**Re: Status of Improvement Permit Application #17-5-41640**

An attempt was made to evaluate your property for the purpose of issuing an Improvement Permit. The evaluation could not be completed for one or more of the following reasons.

275 COTTLE LAKE DRIVE

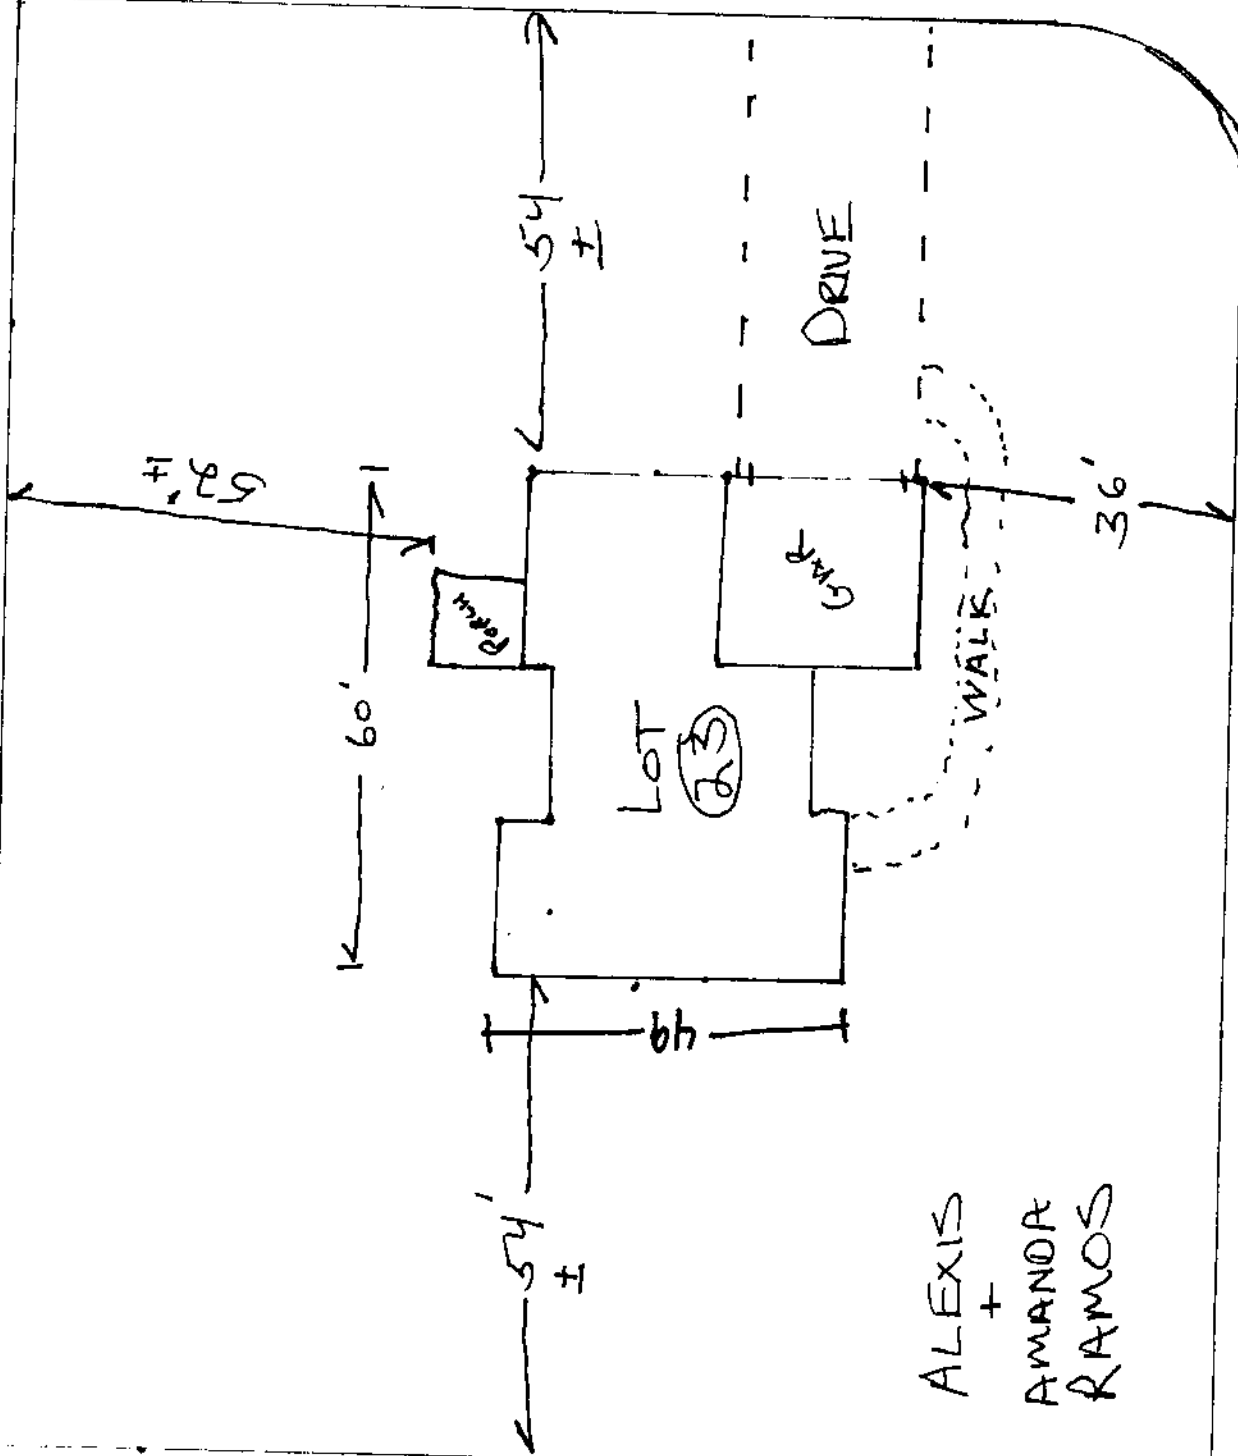
- 1. Use pink flags to mark property lines and irons that are set by surveyor need to be visible, irons shall be displayed or surveyed (\$25.00 fee incurred)
- 2. Use orange flags to mark house corners (\$25.00 fee incurred)
- 3. Directions not clear to property (\$25.00 fee incurred)
- 4. Property needs only brush or vegetation removed
- 5. Driveway not shown on site plan
- 6. Backhoe pits required
- 7. Other
